Our ref: PJB/ASP/DM

Date: 14/12/2012

PROPOSED: Installation of an Endurance E3120 turbine, with a 24.8m hub height and total height of 34.5m to the vertical blade tip, on land owned by the applicant containing no Title Deed restrictions to developments. The Hills Farm, Higher Road, Longridge (3/2012/1021)

Drawing No:	1256/2520	Project:	The Hills Farm Wind Turbine
Revision:	V1	Drawing Title:	Existing Site Plan
Date:	12 Oct 12	Scale:	1:500 @ A2

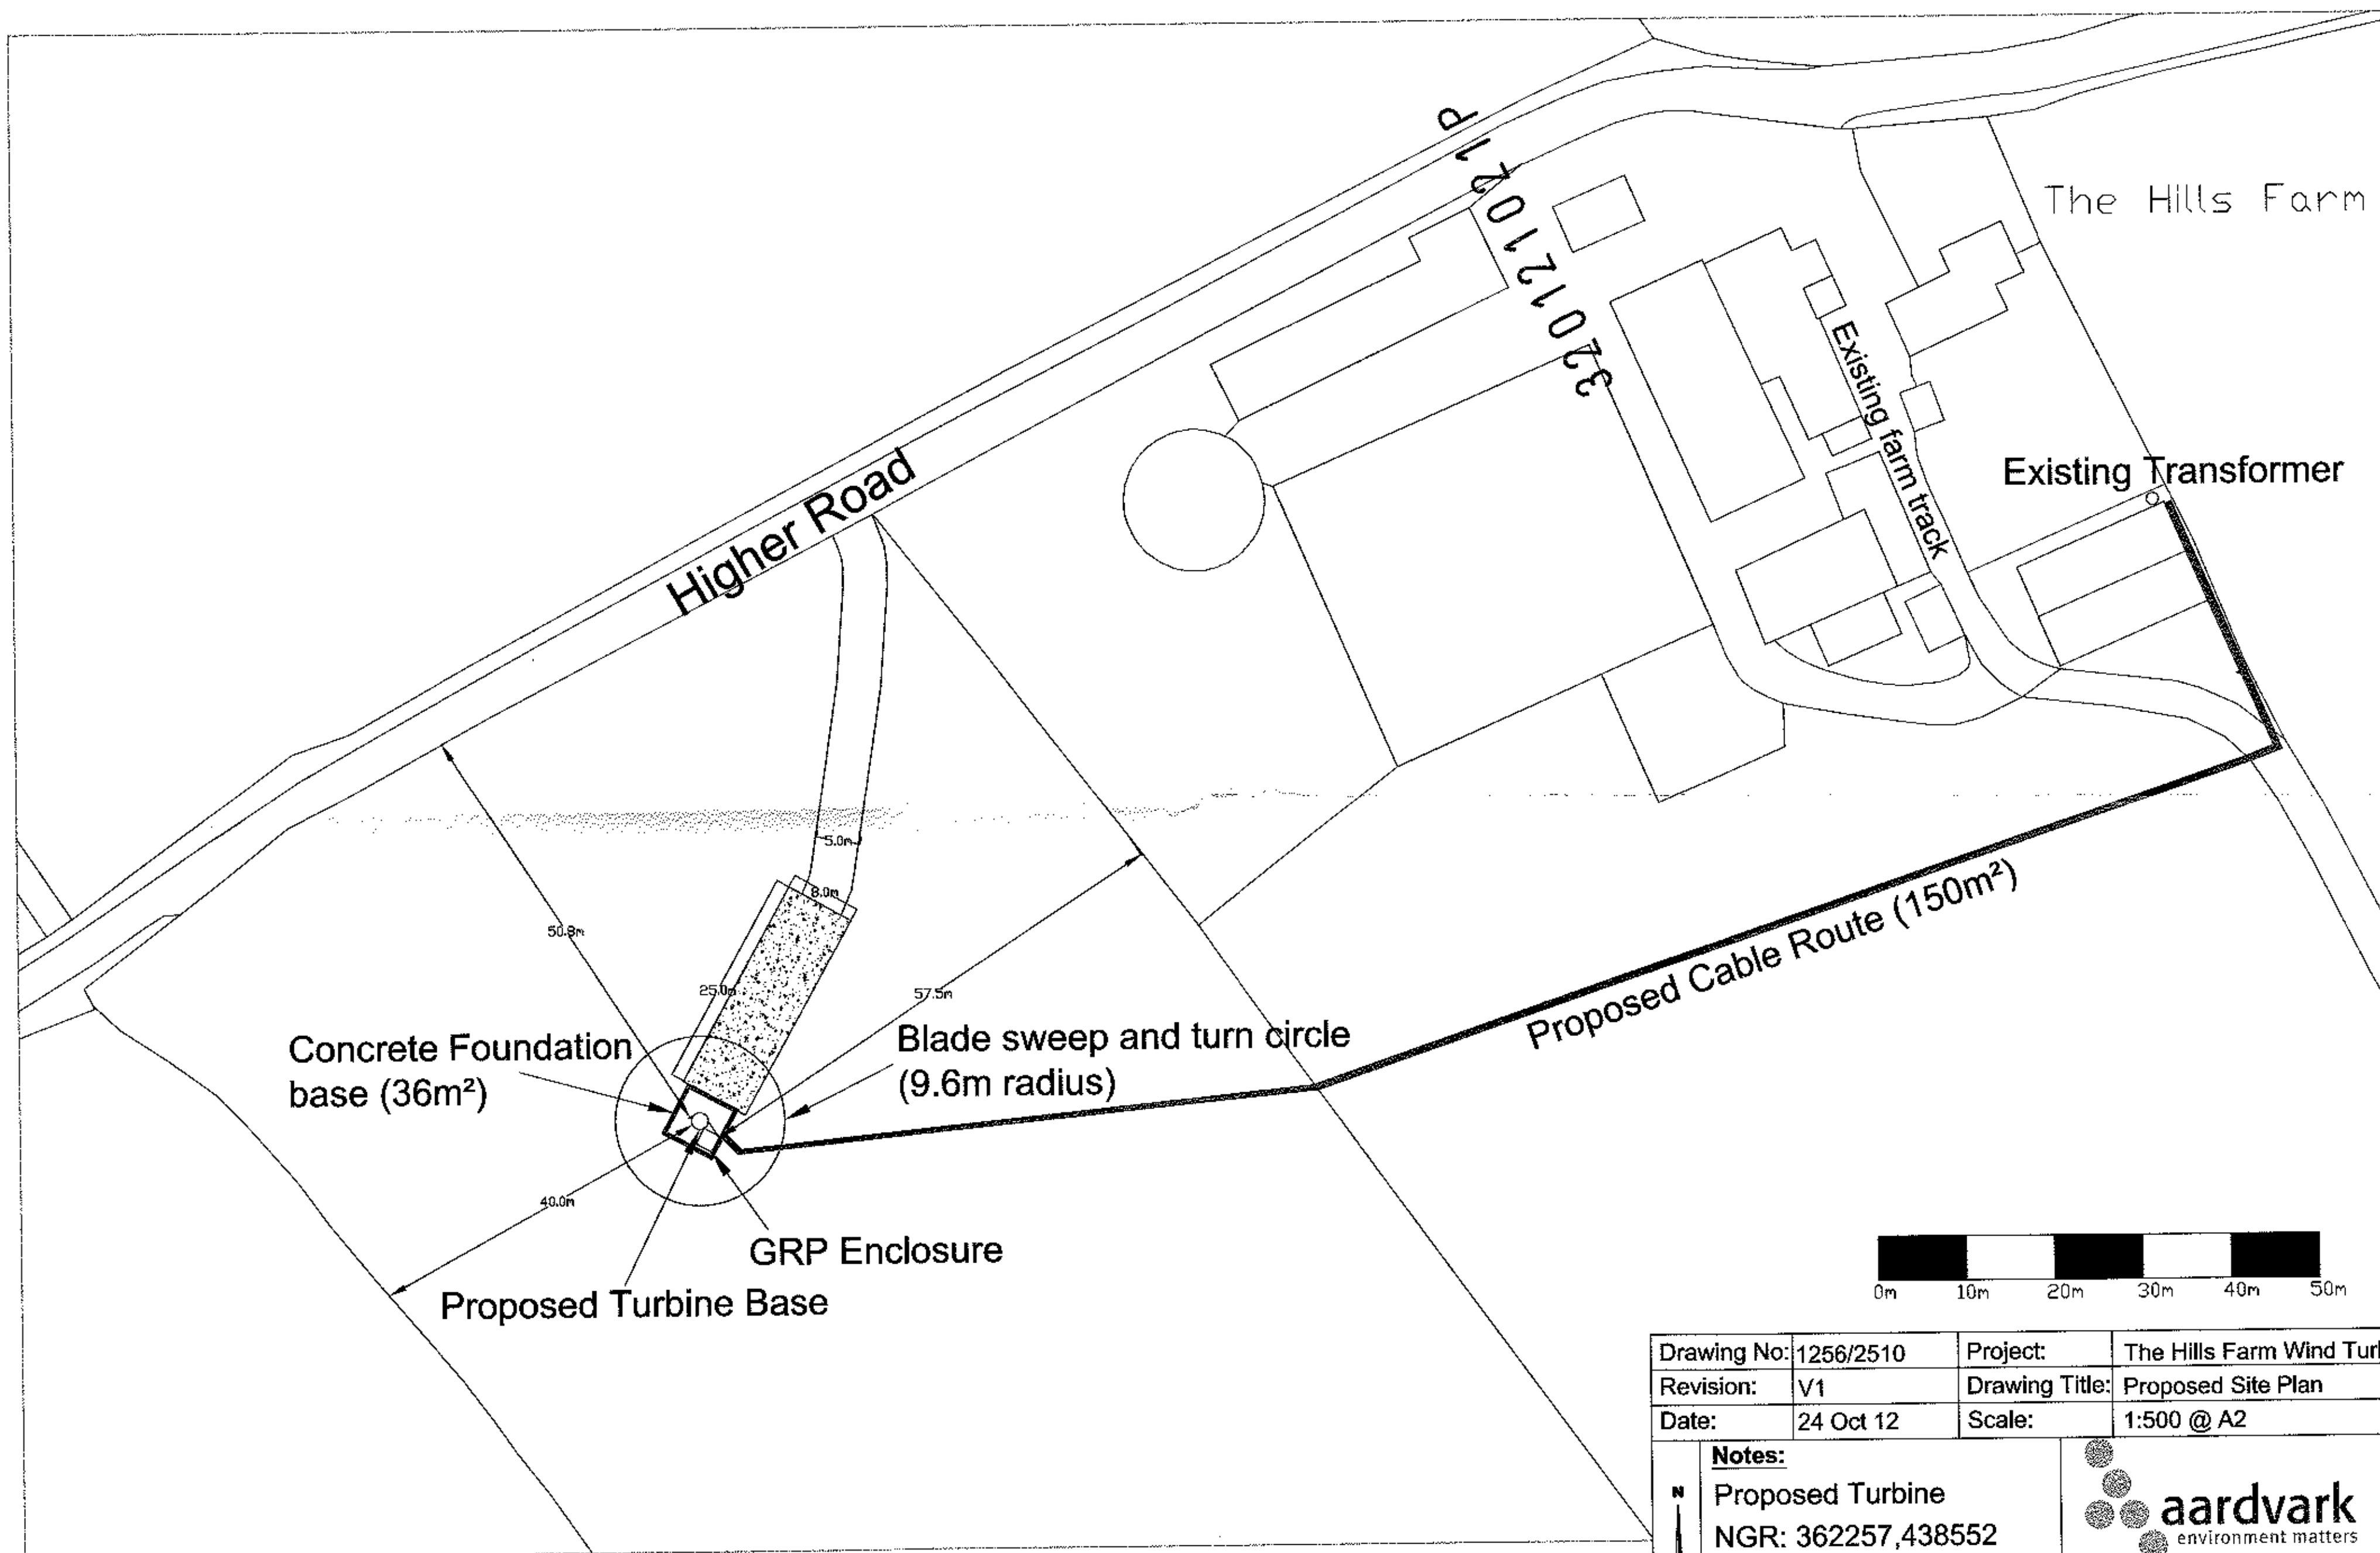
The Design and Access Statement shows that the proposed cable route from the turbine to an existing transformer will cross the line of the road. Mention is also made (p. 9) that a "new farm track (425m²) will be constructed from the farmstead to the turbine site". Although this is not shown on the plans and no details as to its construction have been supplied, it would be anticipated that if it were to run in a east to west direction from the farm it too might cross the line of the road.

Consequently there is a potential for the current proposals to encounter the below-ground remains of the road. LCAS would therefore recommend that should the Local Planning Authority be minded to grant planning permission to this or any other scheme, an archaeological watching brief be undertaken during any groundworks, and that such work be secured by means of the following condition:

Condition: No works shall take place on the site until the applicant, or their agent or successors in title, has secured the implementation of a programme of archaeological work. This must be carried out in accordance with a written scheme of investigation, which shall first have been submitted to and agreed in writing by the Local Planning Authority.
